Re: **Framing Issues**
Location: Lot 1 Griffon Pointe – 17 Drathaar Ct. (Lillington, NC)
JDS Project No.: RDU2301880
Date of Inspection: 03/16/2023

A representative of JDS Consulting arrived on site to observe the issues reported to us by the client, which are presented, along with our recommendations, in this report.

1ST FLOOR FRAMING PLAN
 ELEVATION B
 WALLS AND CEILING
 1/8" = 1'-0"

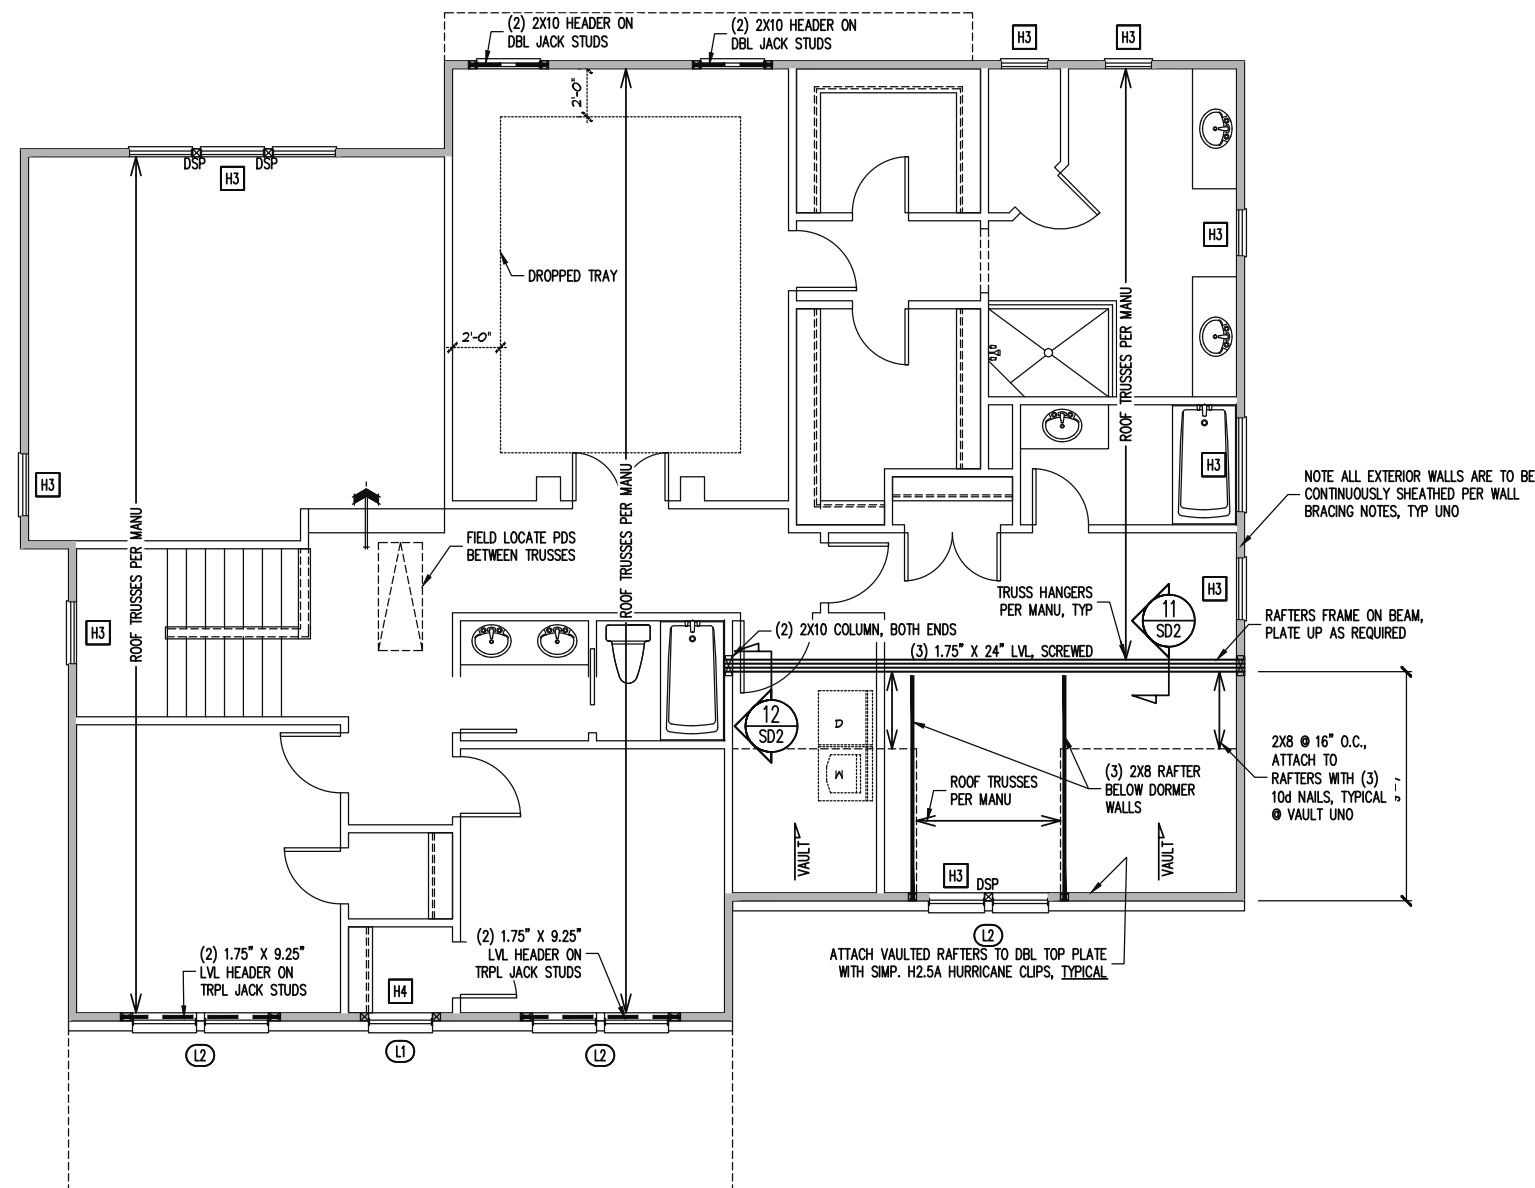
1. The (2) 1-3/4" x 9-1/4" LVL header above the rear door has been installed beneath the double top plate of the wall instead of providing direct bearing for the (3) 1-3/4"x16" LVL beam spanning left to right.
2. The (3) 1-3/4" x 24" LVL beam above 'Bedroom #4' has been installed with (4) 2x4 jack stud columns on both ends and LVL plies attached with nails, in lieu of (2) 2x10 stud columns on both ends and LVL plies attached with screws per page 'S4' and details '11/SD2' and '12/SD2' of the house plans.
3. Concerns regarding the water table attachment at the exterior front garage. The water table has been framed with 2x6 rafters at 16" O.C. nailed directly to the house framing.

1. The calculated reaction at the left end of the (3) 1-3/4"x16" LVL beam is within the top plate's perpendicular compression capacity. The (3) 1-3/4"x16" LVL beam bearing condition at the left end is adequate as installed.

2. The calculated reaction at the left and right end of the (3) 1-3/4"x24" LVL beam is **NOT** within the top plate's perpendicular compression capacity. The contractor shall install a full-depth vertical 2x8 block at each end of the beam. Attach with (4) equally spaced 1/4"x6" SDS screws, ensuring a minimum 4" end distance and 1-1/2" edge distance. The block shall bear fully over the top plates. Finally, ensure the beam plies are attached together per detail 11/SD2. The beam is side loaded and requires the fasteners specified to distribute the loads through all plies.
